Application for approval of details reserved by condition.
Town and Country Planning Act 1990
Planning (Listed Buildings and Conservation Areas) Act 1990

Number	
Suffix	
Property name	Windermere
Address line 1	Lake Lane
Address line 2	
Address line 3	
Town/city	Barnham
Postcode	PO22 0AD
Description of site location must be completed if postcode is not known:	
Easting (x)	496258
Northing (y)	104633
Description

Demolition of existing 2 storey detached house & construction of a pair of semi-detached replacement dwellings with flood preventative measures.	
Reference number	
BN/23/15/PL	
Date of decision (date must be pre-application submission)	02/11/2015
Please state the condition number(s) to which this application relates	
Condition number(s)	
Condition 5. Development shall not commence until details of the proposed surface water drainage scheme have been submitted to and approved in writing by the Local Planning Authority.

Please find amended drawing 535/01F - Clarification Drawing in response to emails from Arun DC on 3rd August 2020 to clarify Invert Level of southerly mid site Silt Trap, and Invert Levels of Rodding Access points (See below text from correspondence dated 31st

Job no.	Drawing No.	Revision
535	01	F

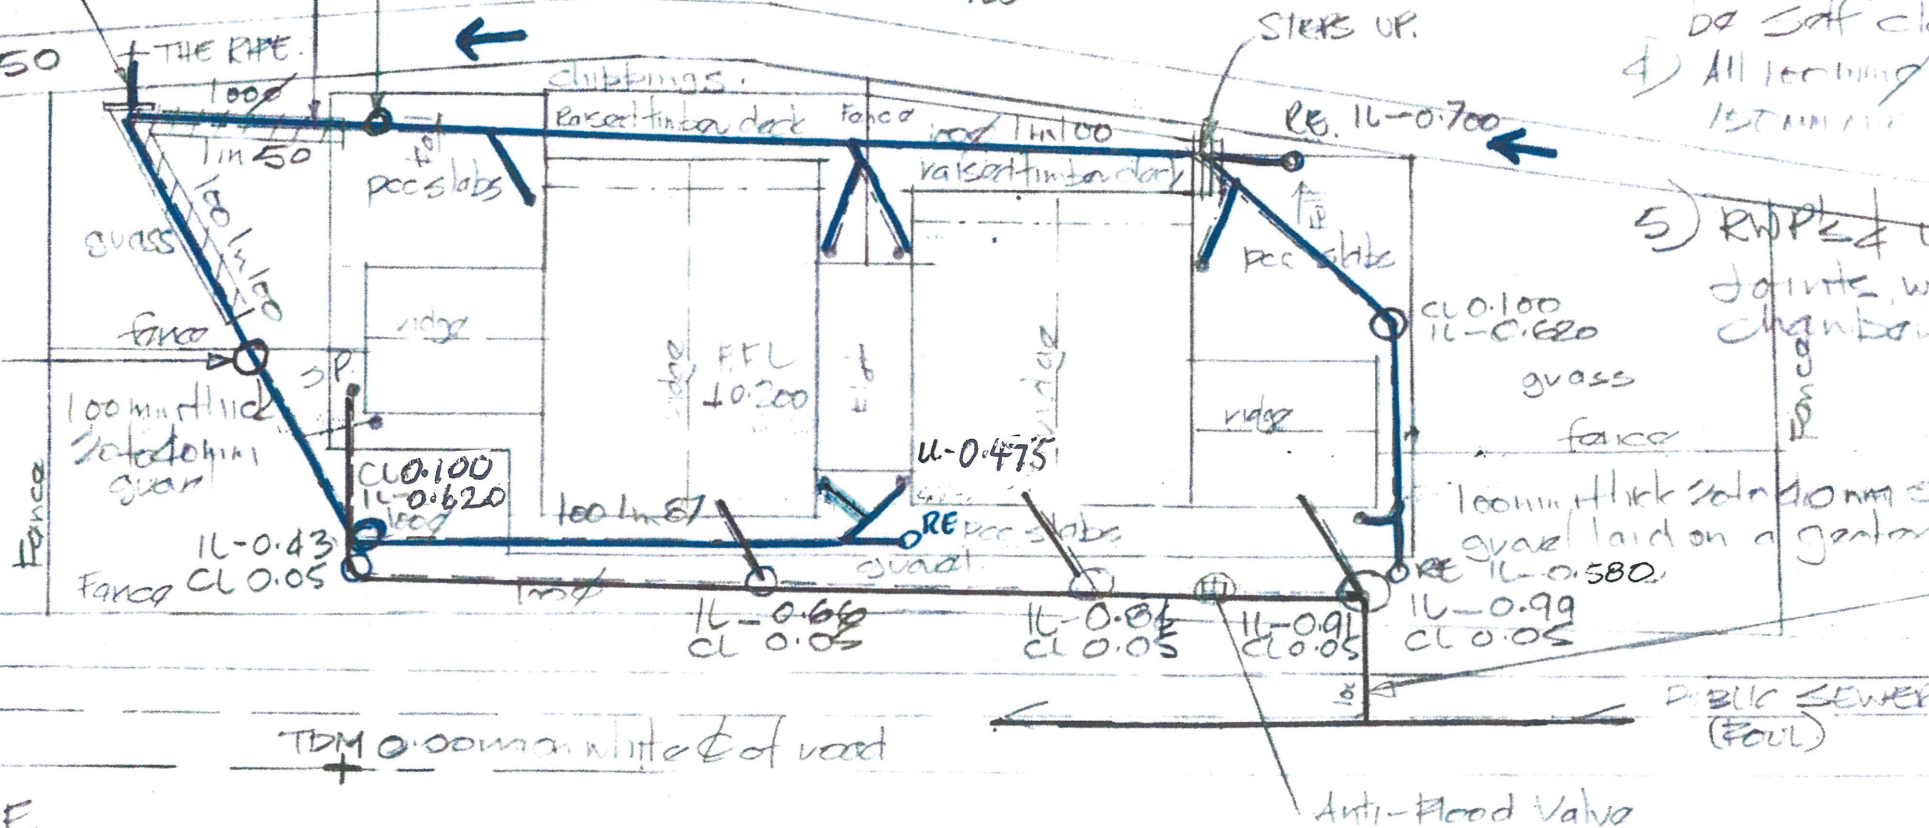
The invert level of the silt trap manhole is not clear (- 0.900?), neither is the rodding eye invert level. Please provide clarity on the drawing.
- Revised drawing 535/02 has not been received.

Clarification can be found on the drawing 535/01F as to the levels on site (surveyed on 6th August 2020), and the levels have been clarified on the drawing.
